CITY OF ALBUQUERQUE

September 24, 2013

**Re: Lot 12, Block 1, Unit 2, Chamisa Ridge, 6216 Wild Onion Ave. NW
Grading and Drainage Plan
Engineer's Stamp dated 08-03-2013 (B-10/D002B)**

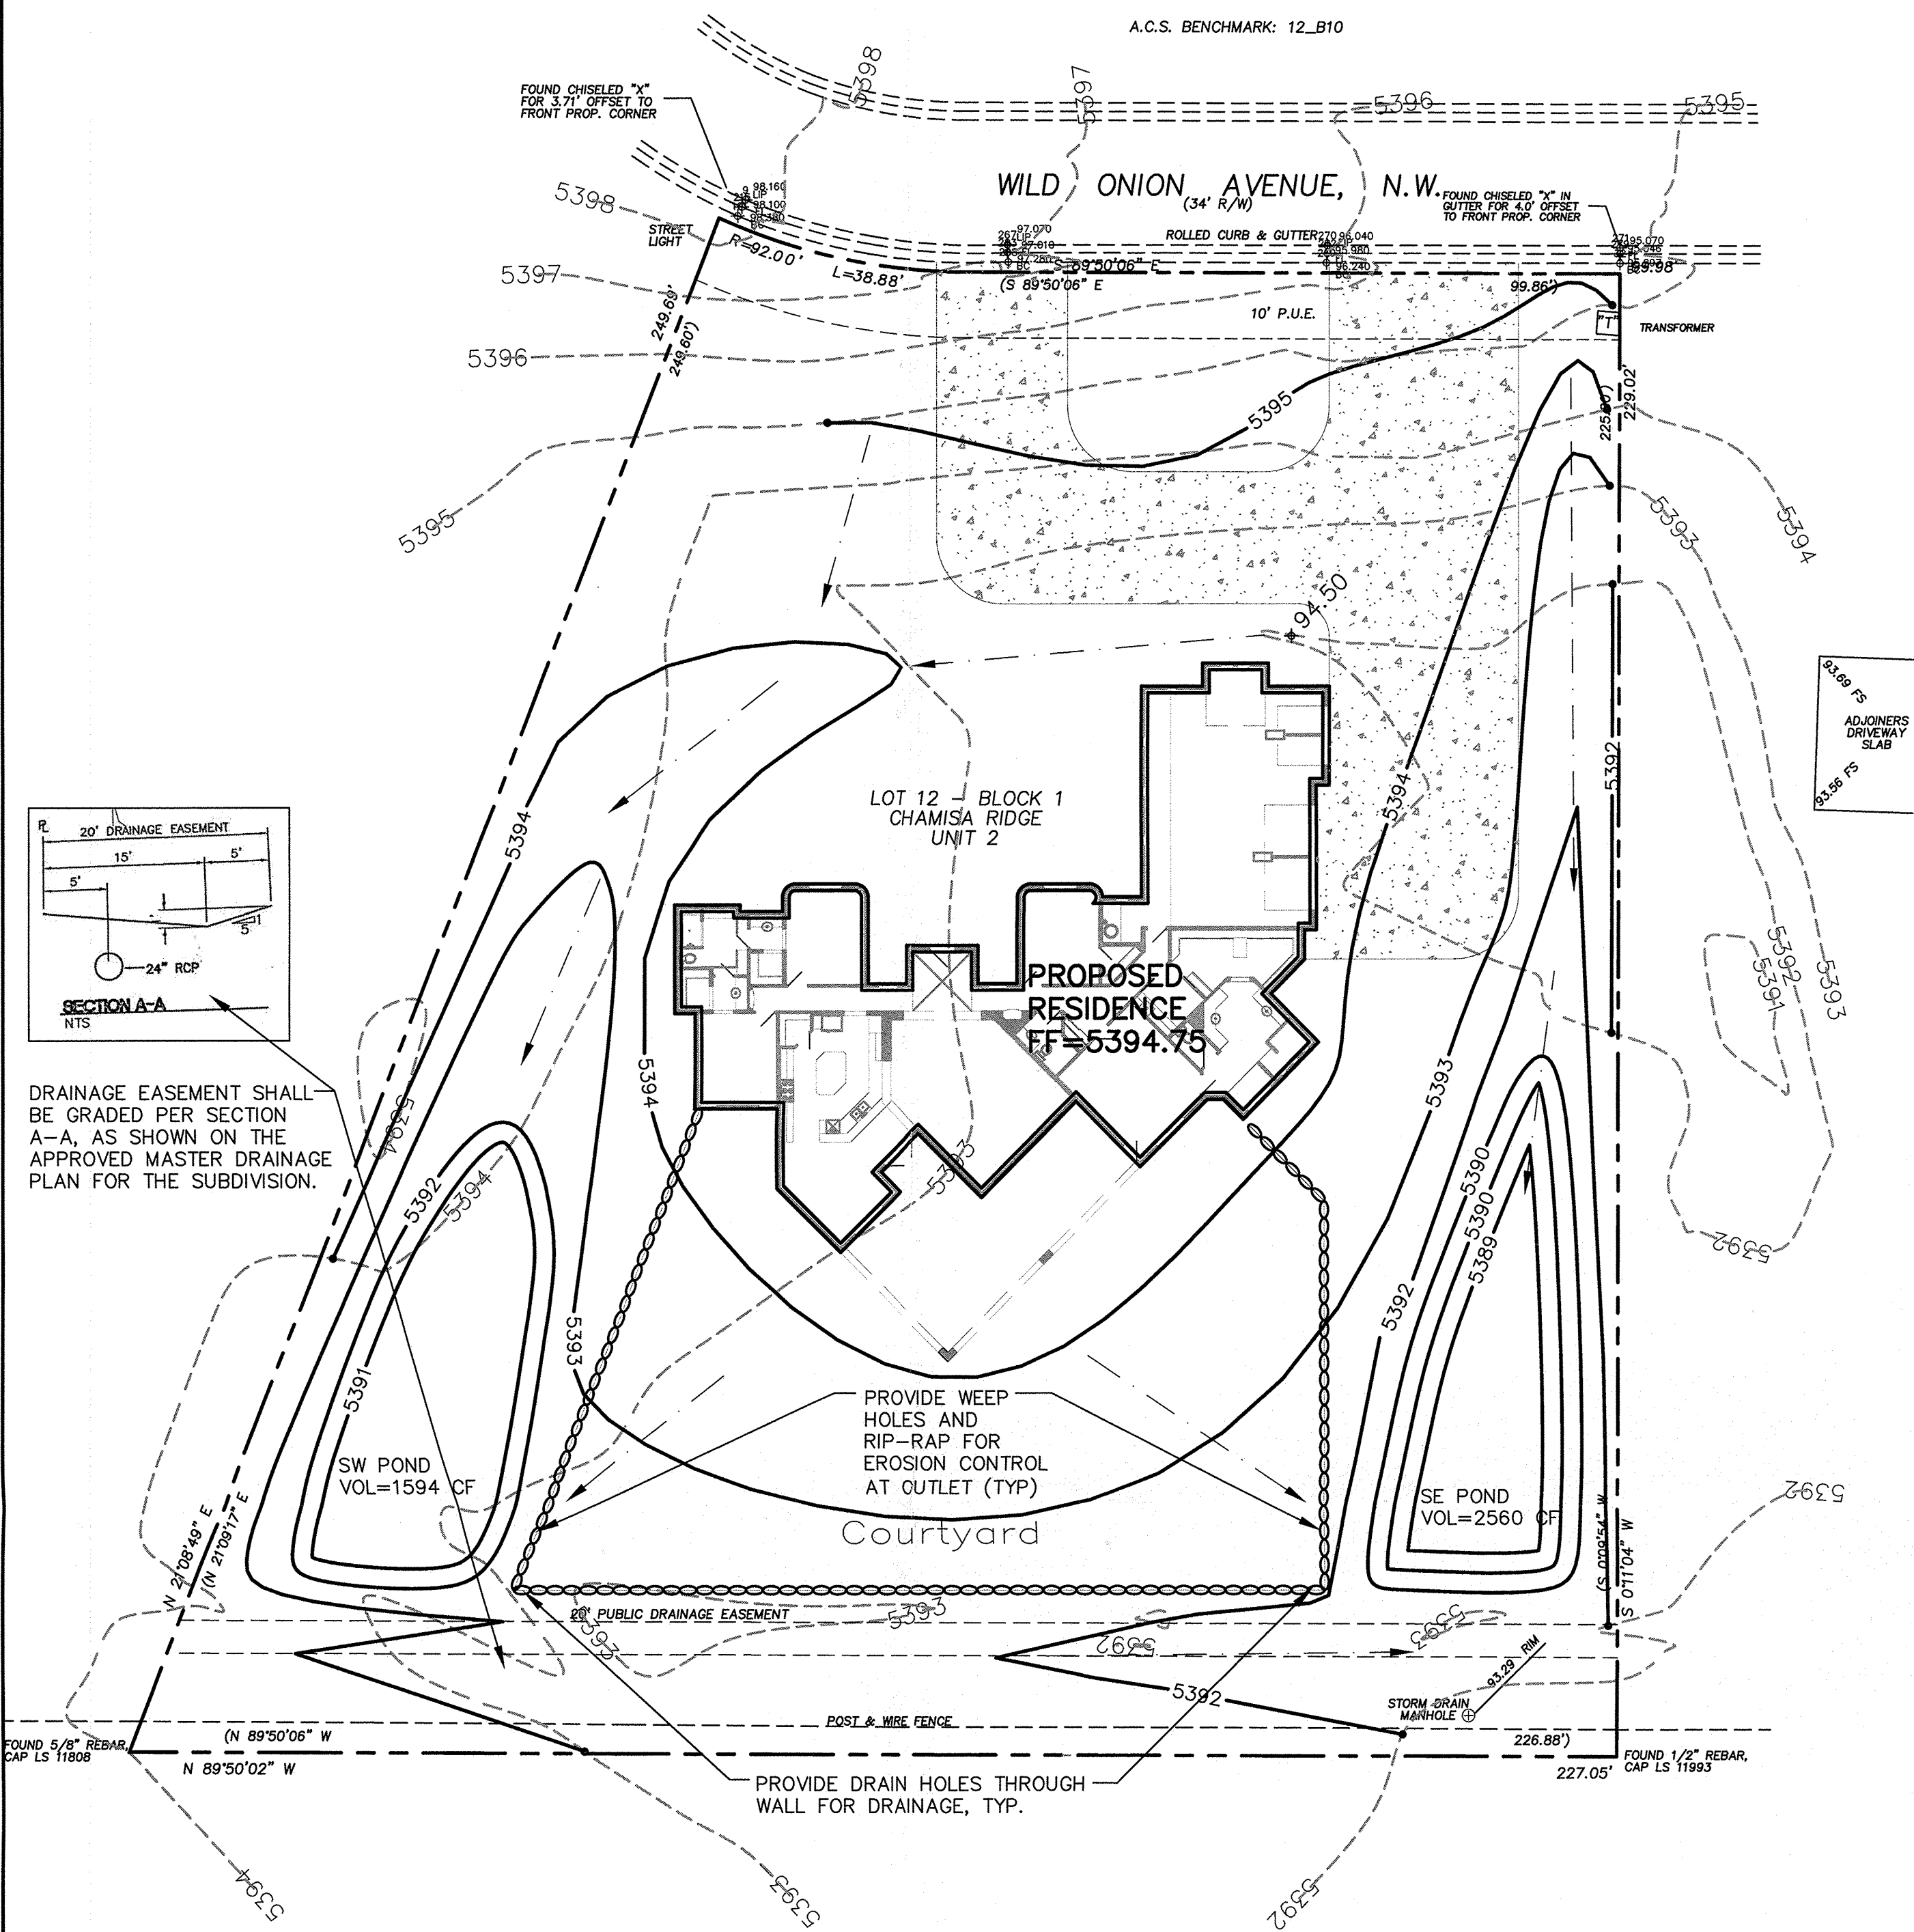
I reviewed your revised Grading and Drainage plan for Lot 12, Block 1, Unit 2, Chamisa Ridge. The elevations provided along Wild Onion are hard to read but it appears that there is only 0.20' of water block.

Will this be adequate for the water block? Provide calculations.

You need to include the street itself as a separate basin as well (+/- 0.70 acre of impervious area).

No other runoff enters the street?

I prepared a more detailed basin measurement - see the attached drawing which is at a scale of 1"=100'. The upstream basin area from Lots A & B and 1/2 street is 89885 sf = 2.06 ac (see attached map & calc). The developed flowrate from this basin is 4.13 cfs (see attached calc sheet). The street capacity is 4.38 cfs. According to the approved Drainage Report for Chamisa Ridge, Unit 2, this is the runoff that enters the street at this location (see attached photo taken from your files).

Attached are the street capacity calculations you requested. The survey shows that there is an average gutter flowline to top of curb of 0.25'. The attached analysis shows that there is adequate street capacity to handle the upstream runoff at this location.
